**Consultation Response from KC,  
Ecology Unit**

**2022/91477 Land off Lindley Moor Road, Lindley, Huddersfield, HD3 3SX**

**Hybrid Planning Application for the erection of an industrial unit for E(g)/B2 /B8 use with associated access, parking, groundworks and landscaping in conjunction with an outline application for mixed use development use class E(a), E(b), E(g), B2 and B8**

**Date Responded: 07/03/2023**

Project Name: Lindley Moor Road	Drawn: TH	Checked: MB	<b>FOR PLANNING</b>		
Drawing Name: Landscape Masterplan	Date: April 2022		E	MB	07.09.2023
Drawing No: DR-4823-01	Scale: 1:500 at A0		D	TH	27.09.2022
			C	TH	24.05.2022
			Rev	Drawn	Date

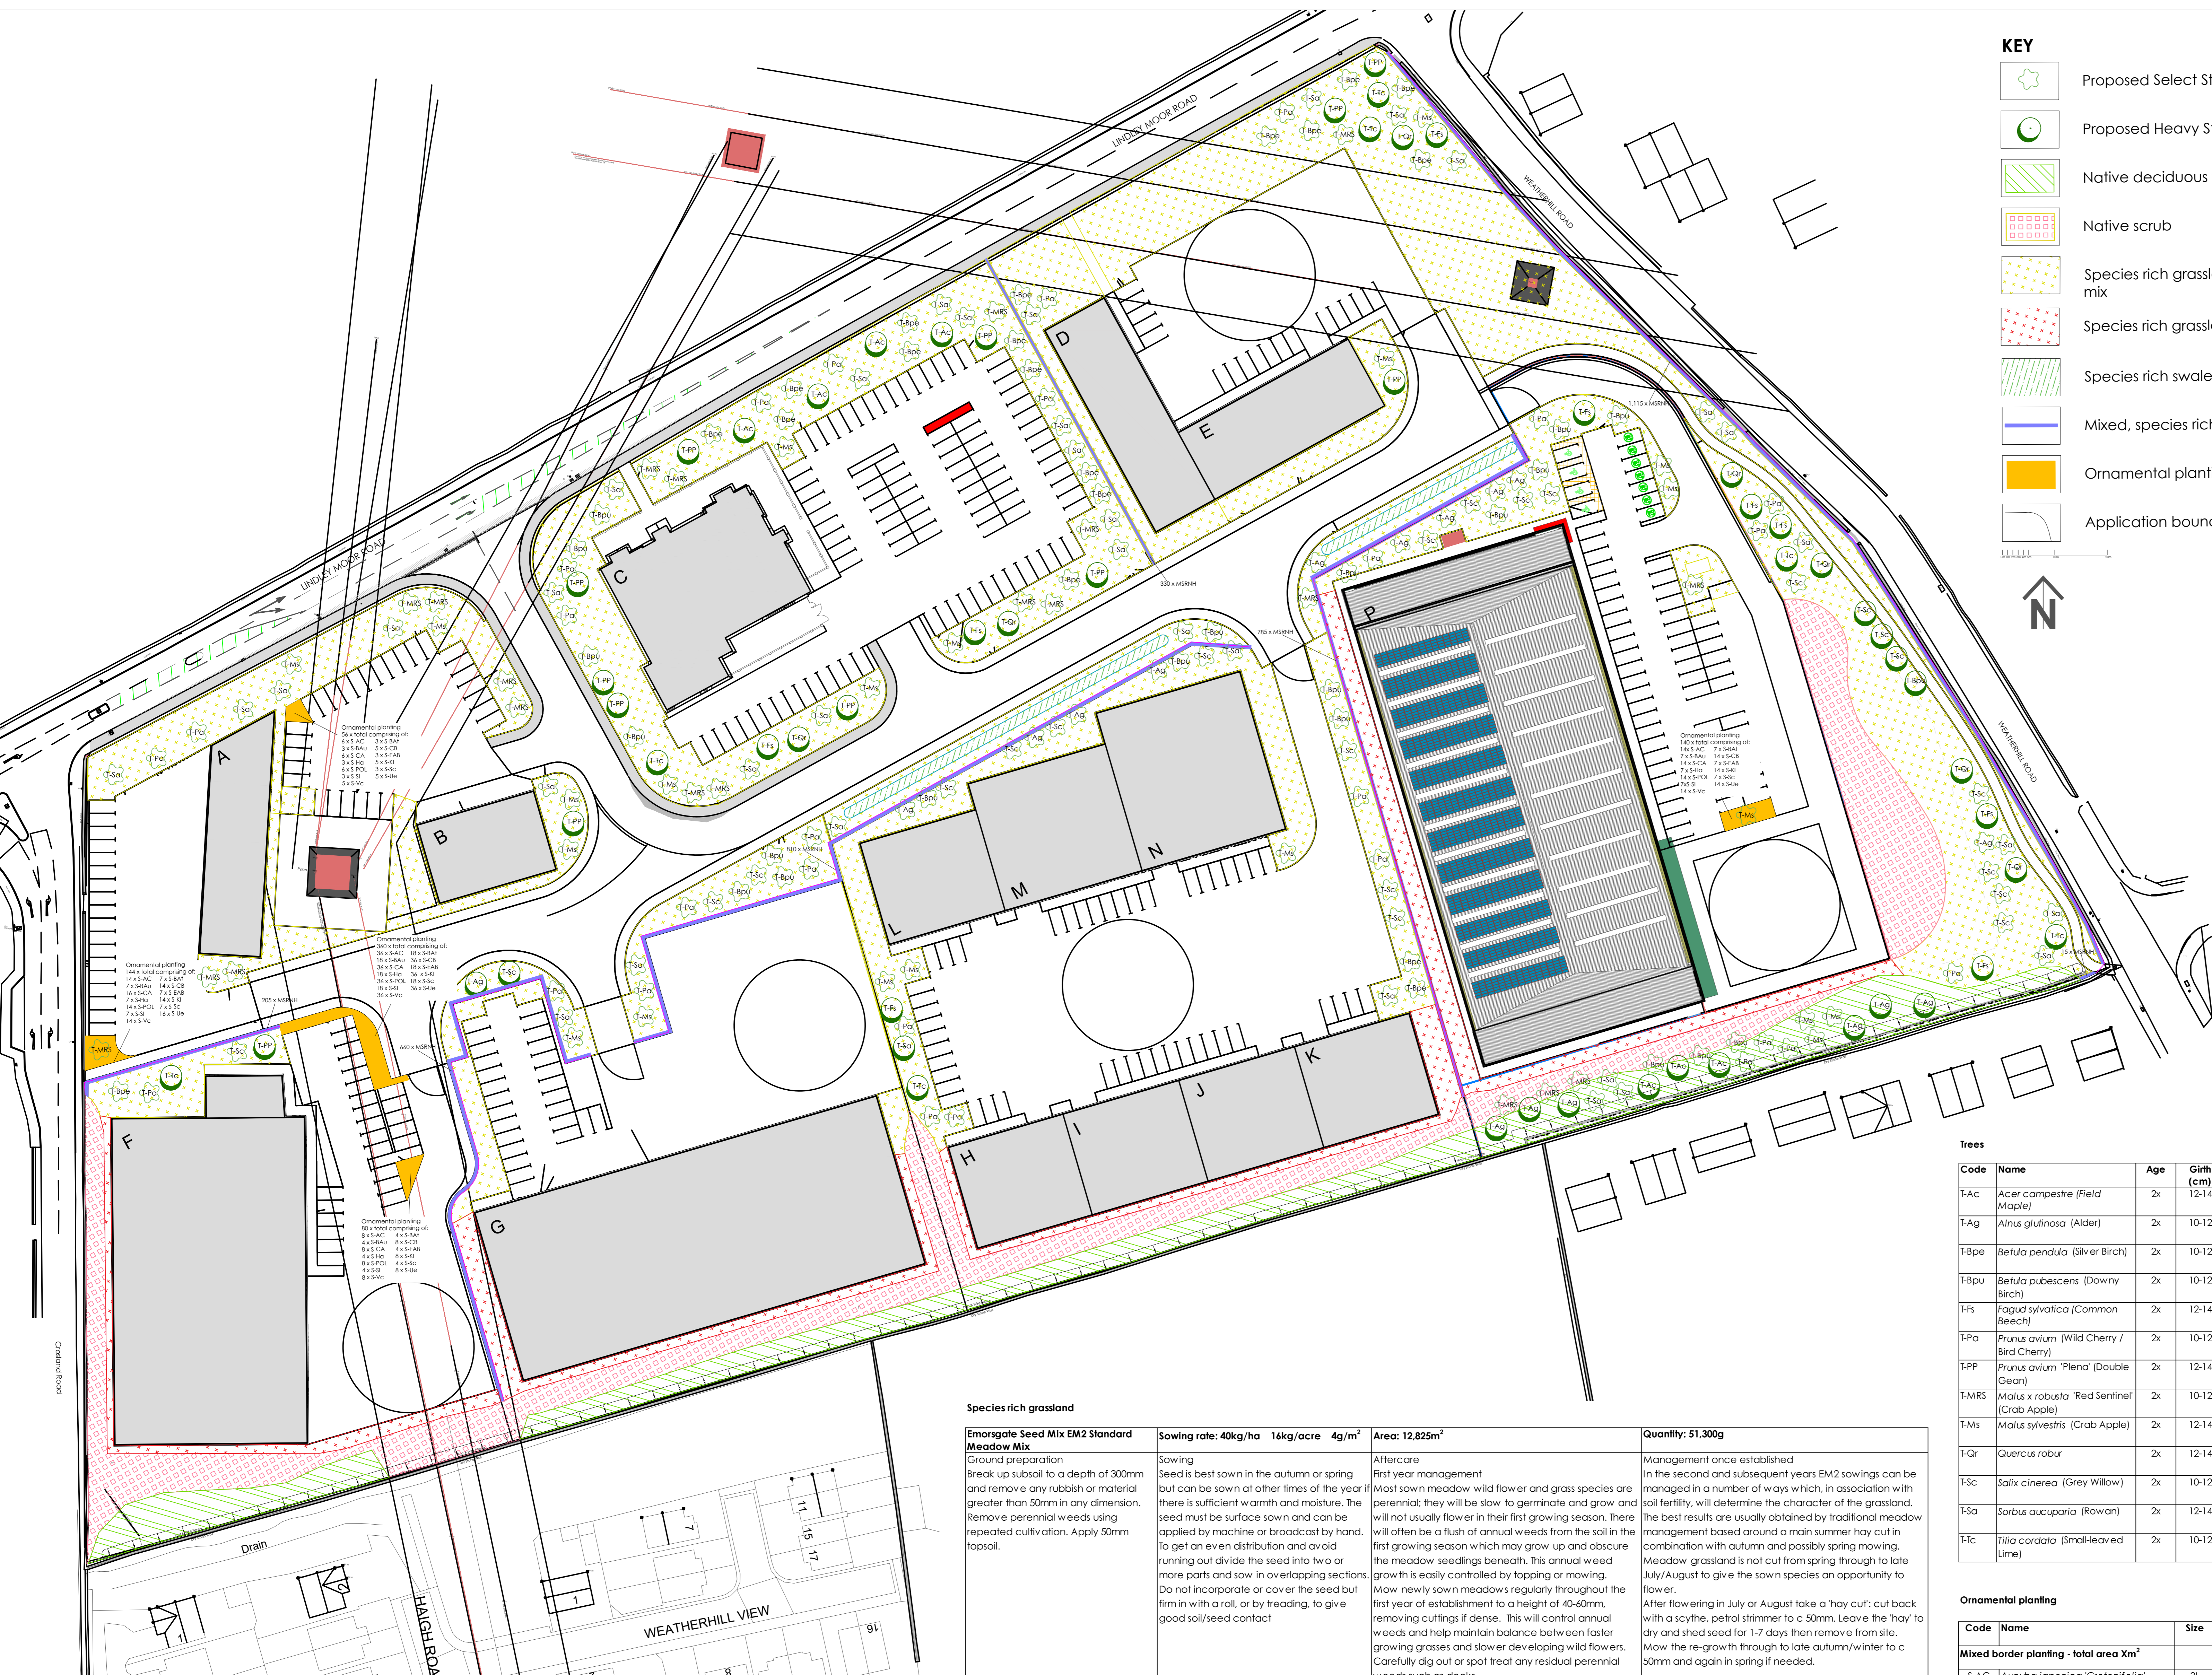
A Biodiversity Net Gain calculation has been submitted with the EclA, using the Biodiversity Metric 3.0 calculator tool. However, since the submission of this report, the landscaping proposals have changed, providing a number of additional trees, with some other minimal changes in habitats. Prior to determination, the metric should be updated, in line with the most up to date landscaping proposals. KC Ecology should then be re-consulted where additional comments can be provided.

Provide updated BNG metric, in line with updated landscaping proposals.
